CITY OF ALBUQUERQUE

May 27, 2020

Re: Stripes Burrito CO#5
801 Juan Tabo NE
Traffic Circulation Layout
Architect's Stamp 04-15-2020(K21-D021)

TCL-02

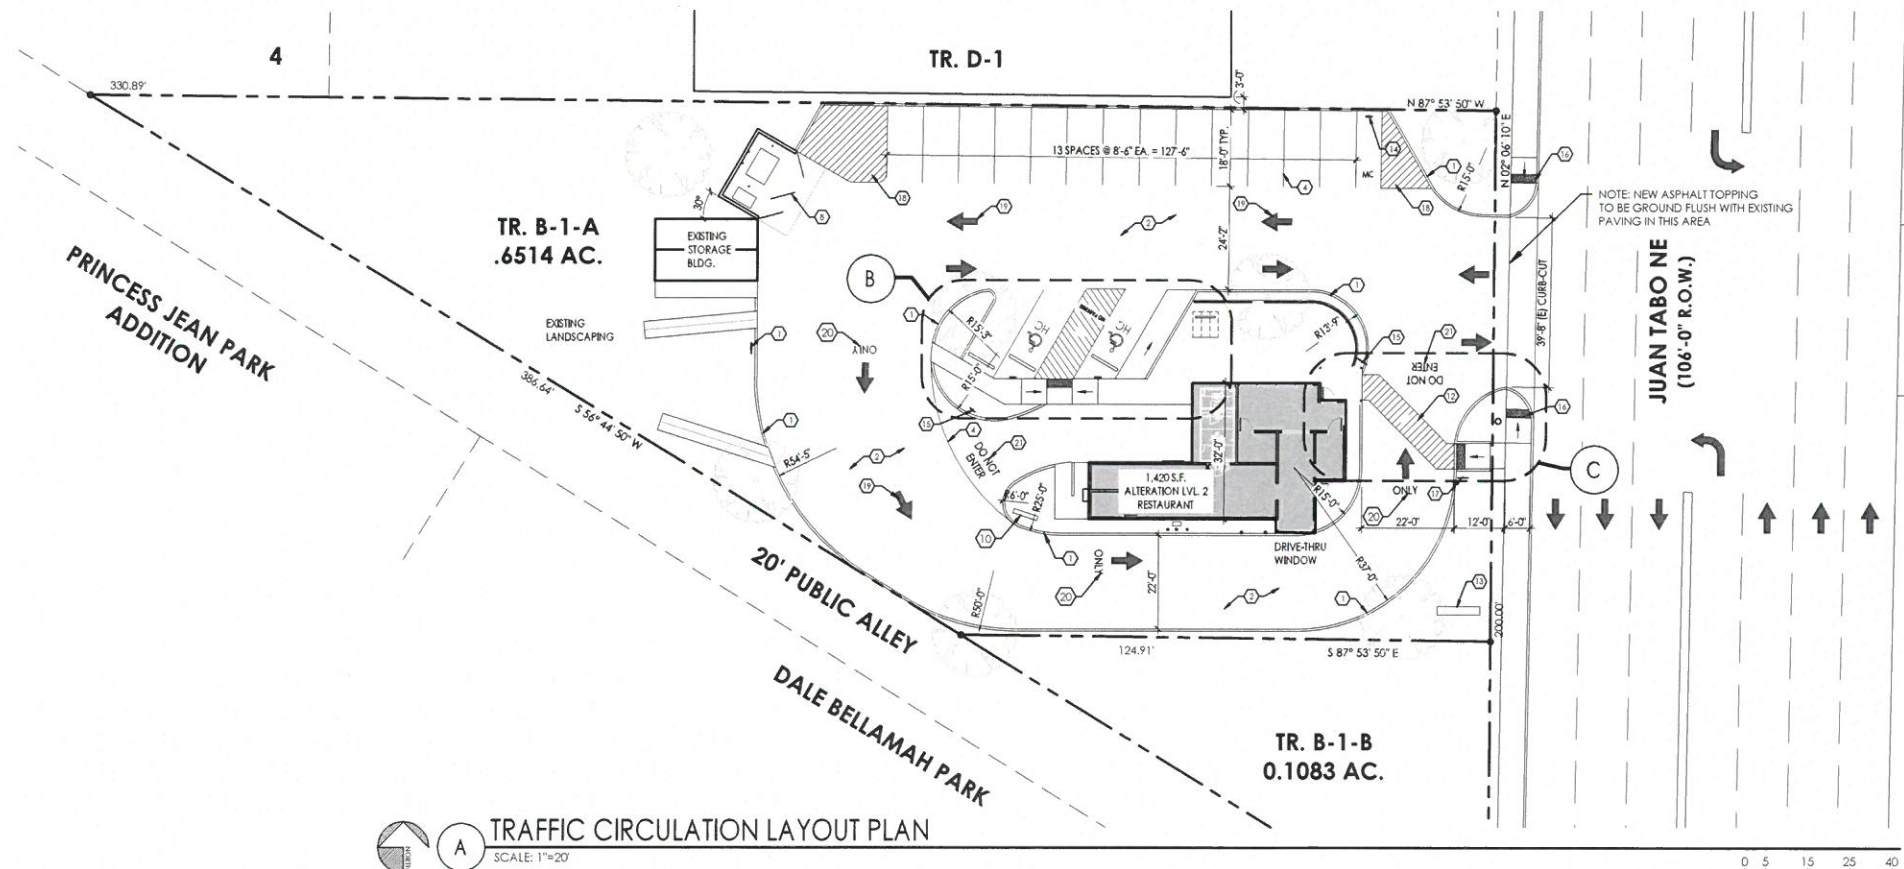
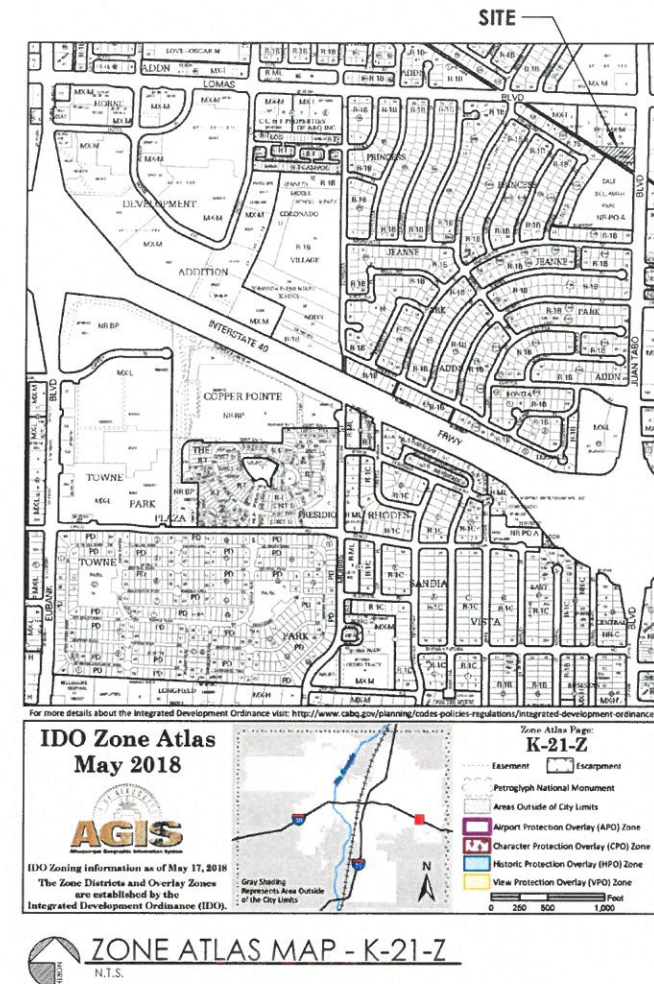
1. Please coordinate with Zoning all calculations for parking spaces, including **bicycle and motor cycle parking (calculations for bicycle, ADA parking stalls and motorcycle not shown, why?)** and listed the number required.
2. Identify the right of way width, medians, curb cuts, and street widths on Juan Tabo NE.
3. The minimum parking stall dimensions are:

- 11. Show all drive aisle widths and radii. Some dimensions are not shown including entrance width.
- 12. List radii for all curves shown; for passenger vehicles. Radius for delivery trucks, fire trucks, etc. is 25 ft. or larger.

- 13. The 6 ft. wide ADA accessible pedestrian pathway from the public sidewalk to the building entrances (6 ft path needs to be provided to the entrance) doesn't have ramps across drive-thru lanes. Please provide these ramps and details. The pathway at public sidewalk is in conflict with existing entrance ramp.

- 14. Per DPM, a 6 ft. wide ADA accessible pedestrian pathway is required from the ADA parking stall access aisles to the building entrances(includes ramp width). Please clearly show this pathway and provide details.

- 18. All one-way drives shall have "One Way" and "Do Not Enter" signage and pavement markings. Please show detail and location of posted signs and striping.

- 19. The minimum drive through lane width is 12 feet with a 25 foot minimum radius (inside edge) for all turns. (A 15 foot radius can be used with an increase in lane width to 14 feet). Please dimension all lane widths and radii. Provide pedestrian crossing signage at drive-thru lanes where 6ft pedestrian pathway crosses lanes.

8 BIKE RACK DETAIL
N.T.S.

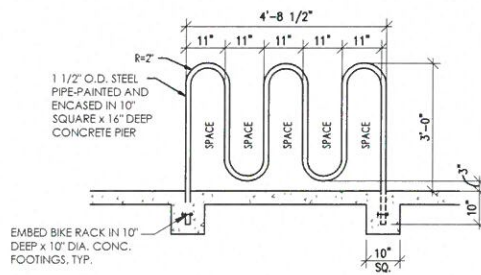
4. The ADA accessible spaces must include an access aisle. Van accessible aisles should be 8ft wide; all others should be 5ft wide.
5. ADA curb ramps at the Juan Tabo entrance must be updated to current standards and have **truncated domes installed**.
6. Motorcycle parking spaces shall be designated by its own conspicuously posted upright sign, either free-standing or wall mounted per the zoning code. Label pavement MC.
7. All bicycle racks shall be designed according to the following guidelines:
 - a. The rack shall be a minimum 30 inches tall and 18 inches wide.

- b. The bicycle frame shall be supported horizontally at two or more places. Comb/toaster racks are not allowed.
 - c. The rack shall be designed to support the bicycle in an upright position. See the IDO for additional information.

- d. The rack allows varying bicycle frame sizes and styles to be attached.
 - e. The user is not required to lift the bicycle onto the bicycle rack.
 - f. Each bicycle parking space is accessible without moving another bicycle.

- 8. Bicycle racks shall be sturdy and anchored to a concrete pad.
- 9. A 1-foot clear zone around the bicycle parking stall shall be provided.
- 10. Bicycle parking spaces shall be at least 6 feet long and 2 feet wide.
